**SINGLE + TWO STOREY EXTENSIONS AND INTERNAL ALTERATIONS  
WEST FARM COTTAGE, SIBFORD GOWER**

Further to my email correspondence with George Smith (Senior Planning Officer) between 1<sup>st</sup> - 23<sup>rd</sup> June 2021, we hereby enclose the following documents in PDF format in order to make a variation of condition application to planning permission 20/03601/F:

DETAIL 01
TYPICAL DOOR DETAILS
GROUND FLOOR PLAN
1:20

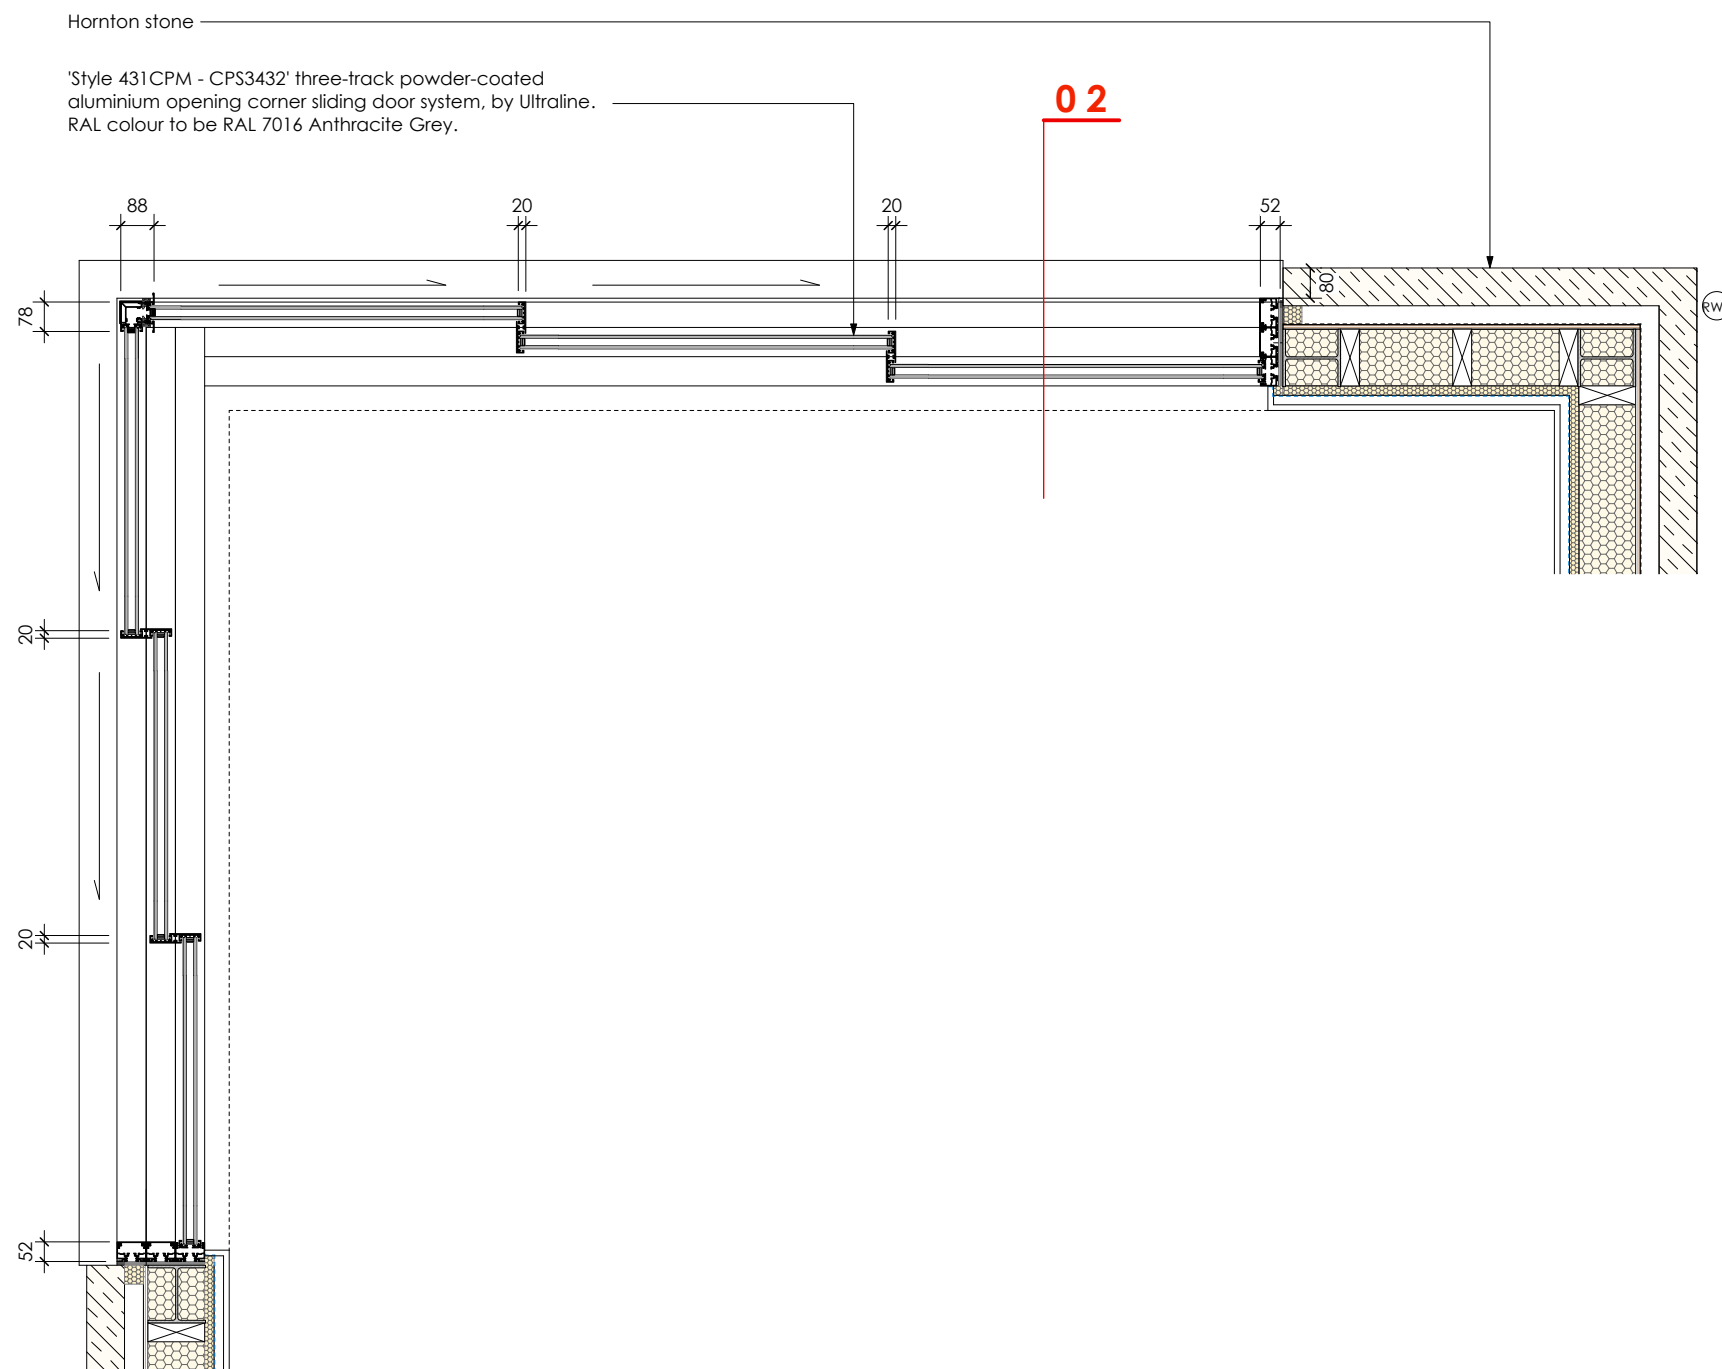
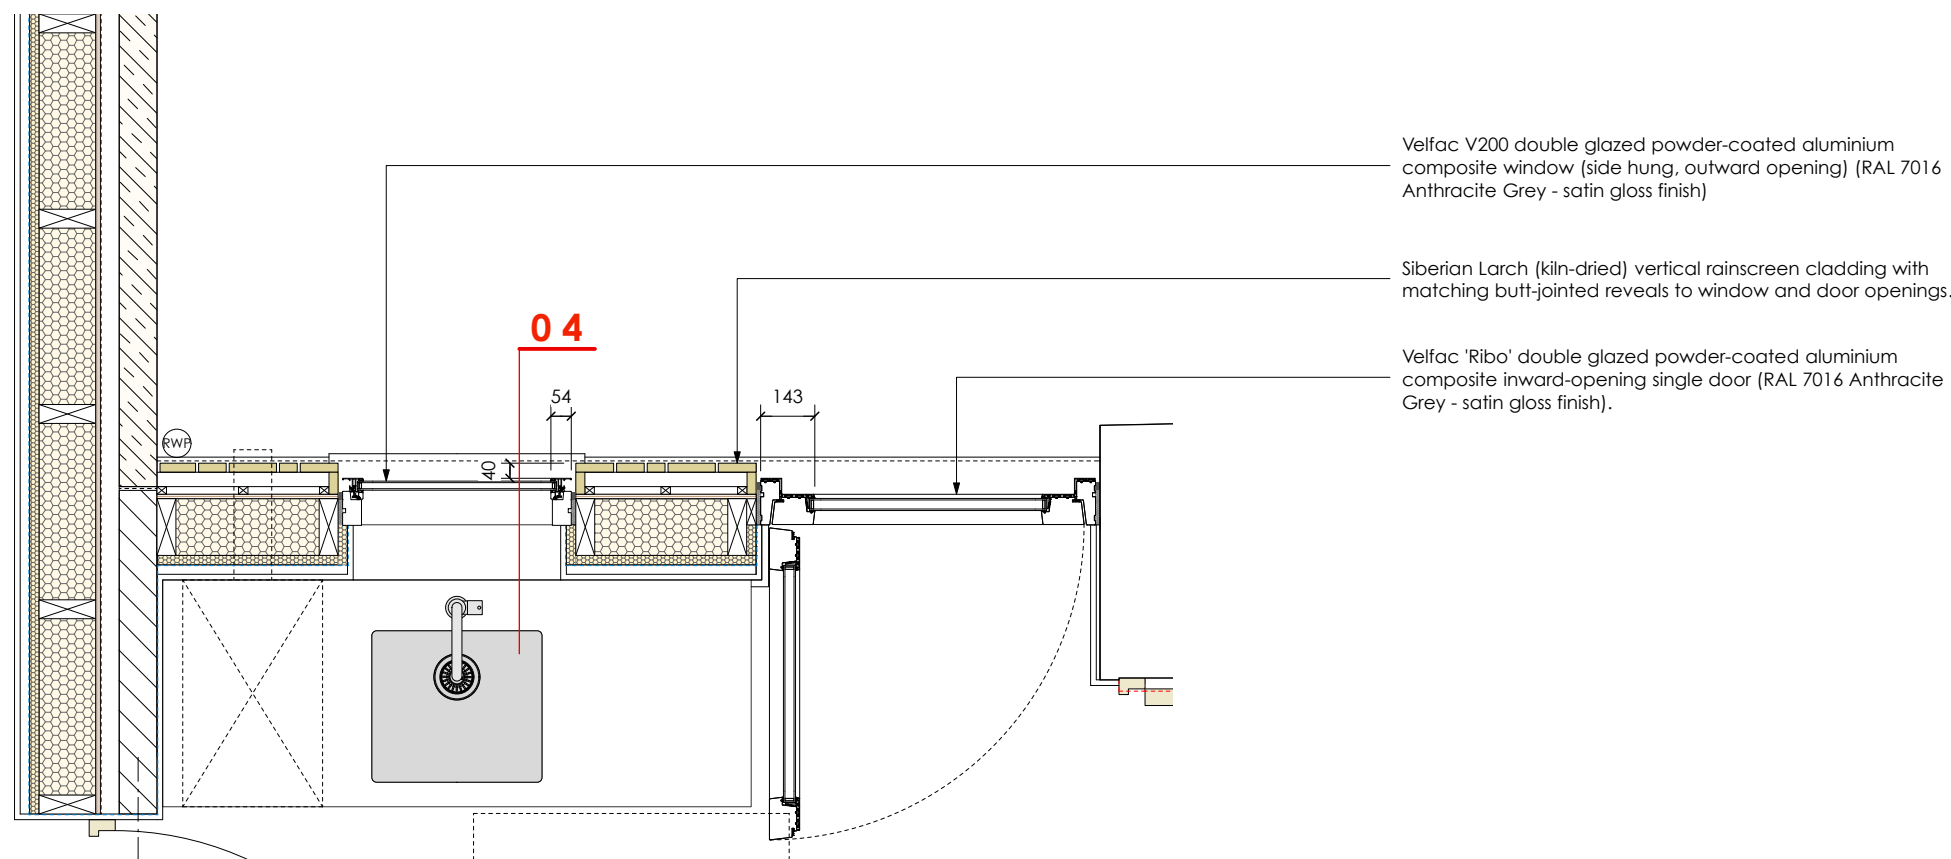
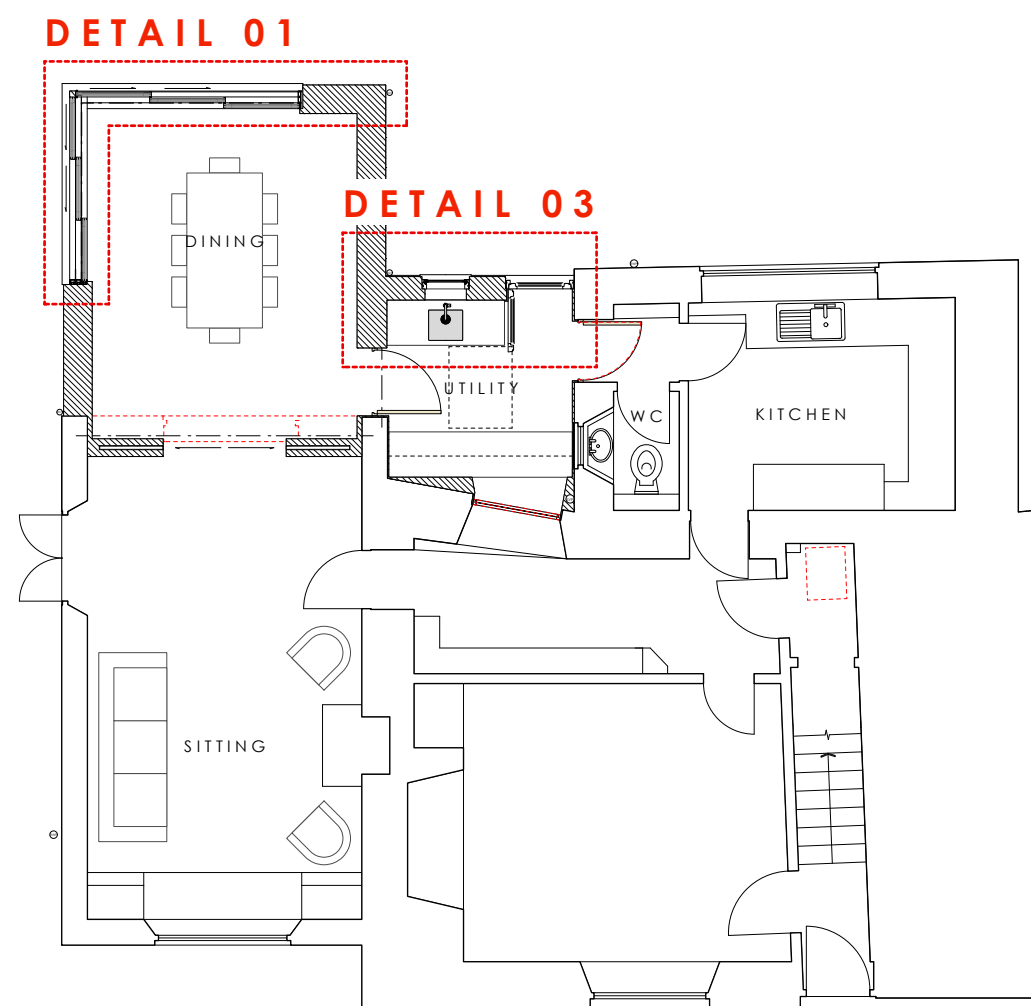
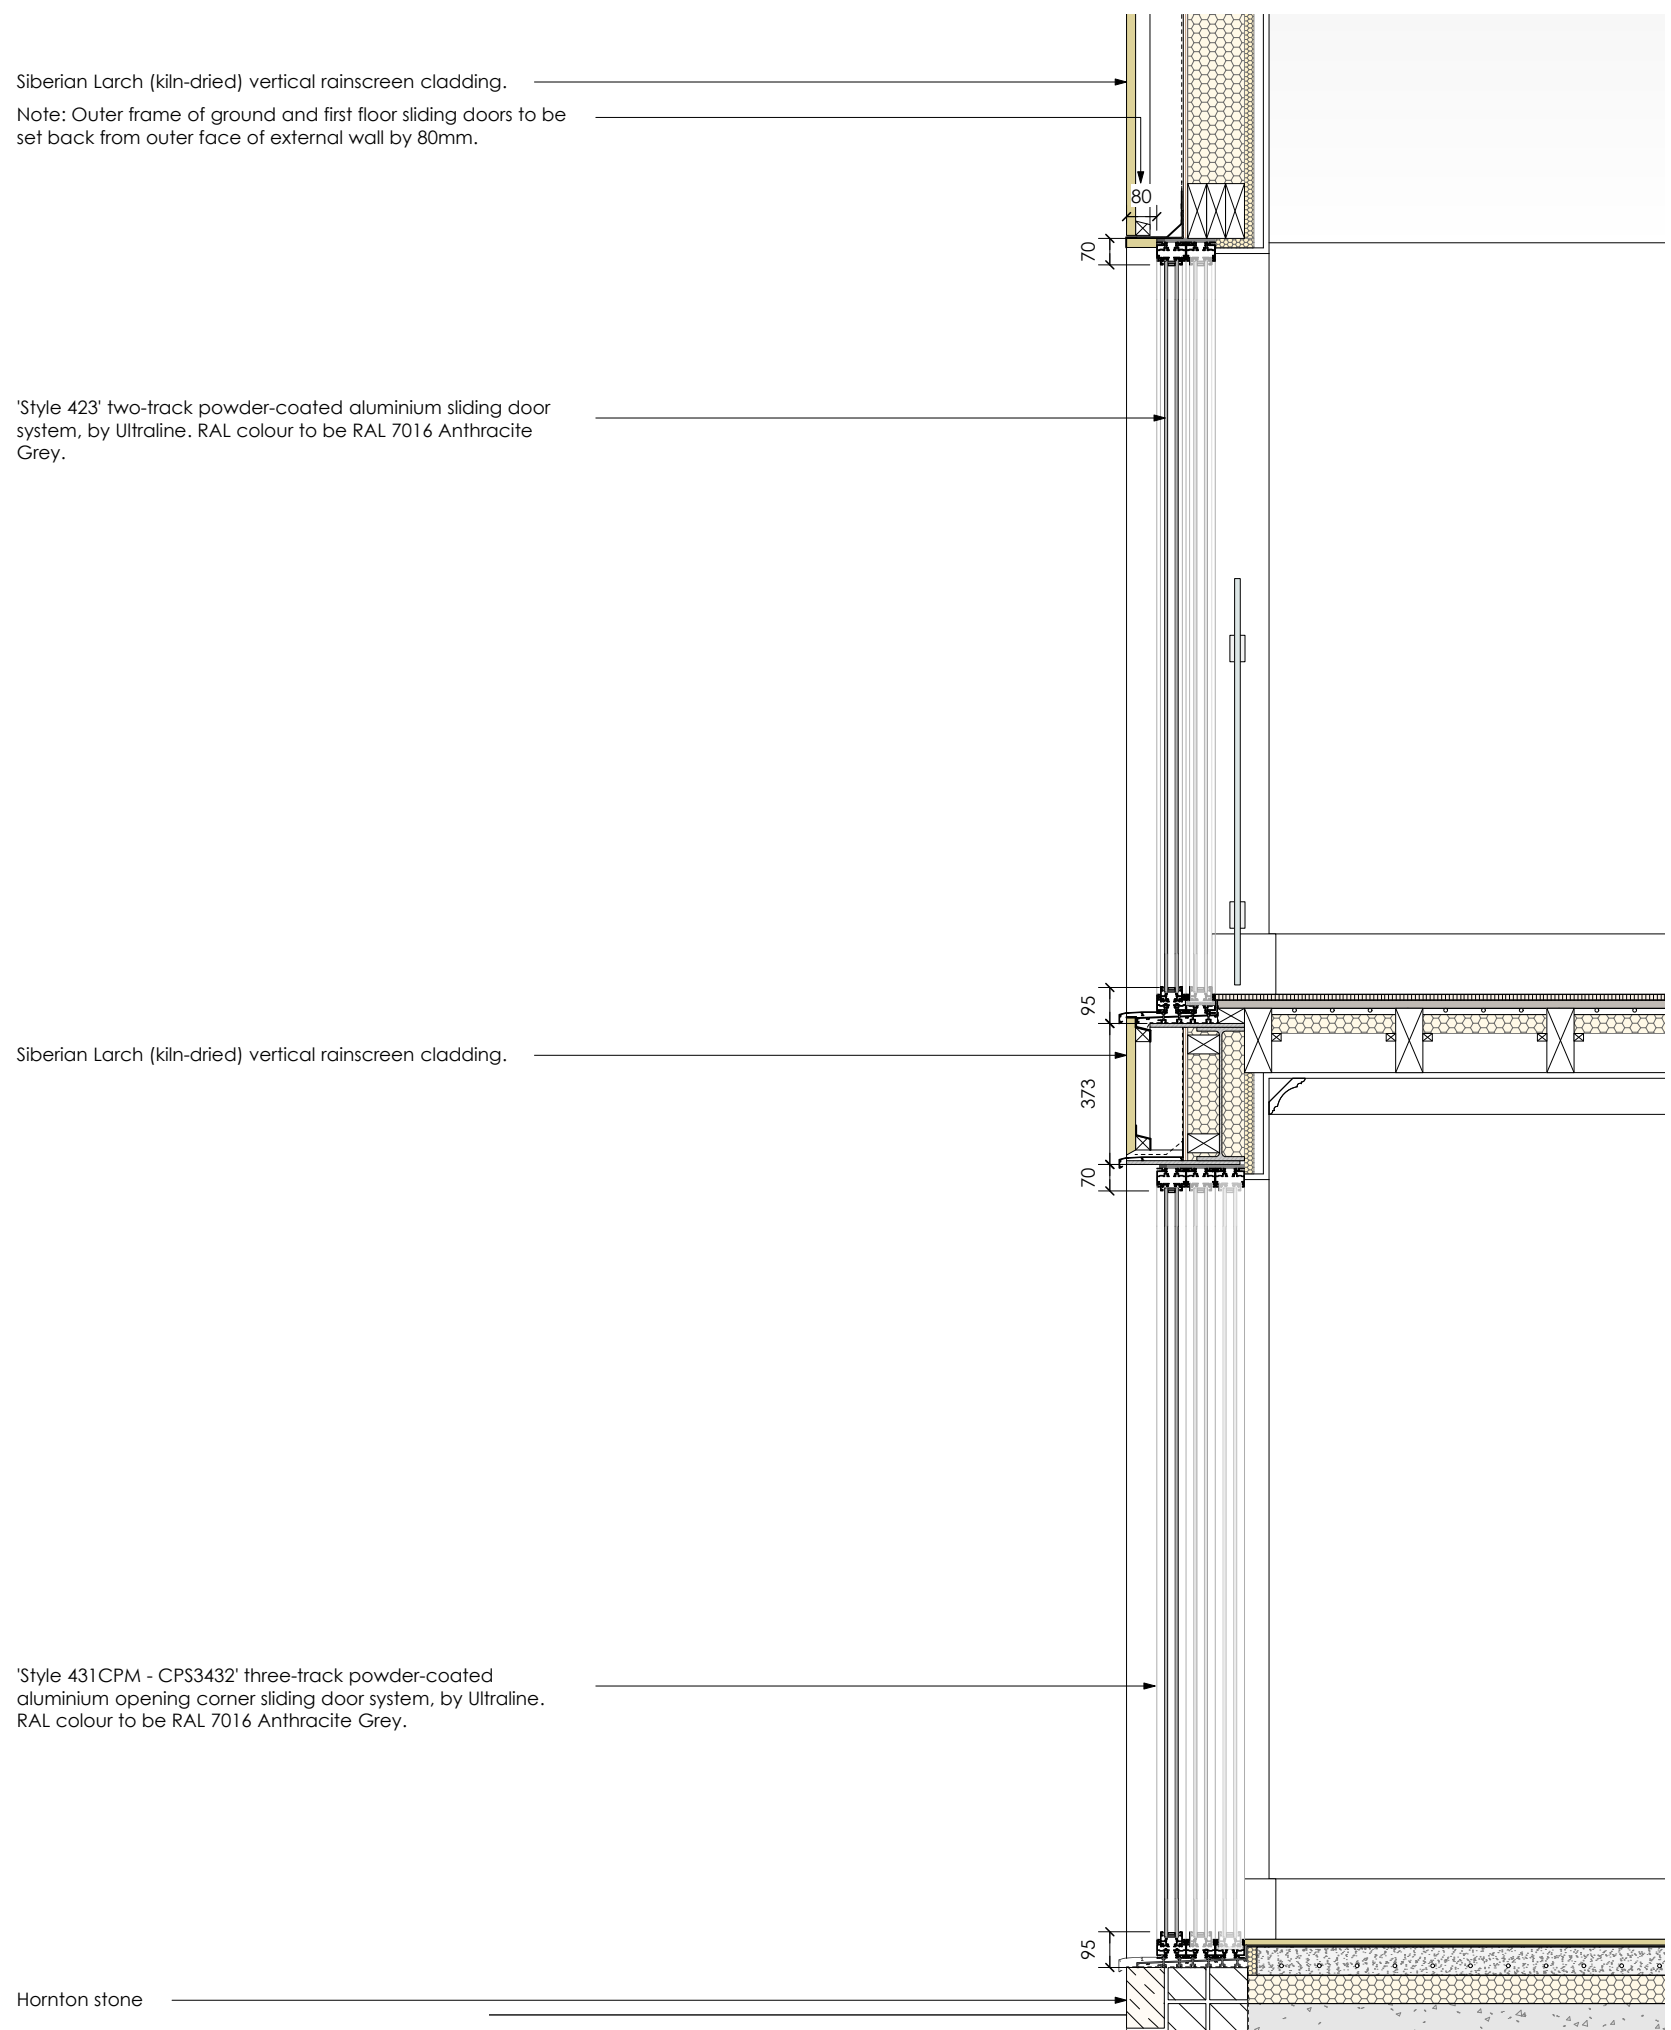
We wish to replace drawing 19\_076-102 with 19\_076-102A to reflect the amended glazing details to the two-storey extension and revised glazing specification for the window and door to the single-storey utility extension.

The replacement specification for a Velfac 'Ribo' glazed inward opening door to the utility extension is identical in terms of detailing and dimensions to the previously approved Rationel 'Auraplus' inward opening glazed door, however, we have switched supplier to Velfac to use a slimmer framed window ('V200') to the north elevation of the utility extension than the Rationel 'Auraplus' previously approved.
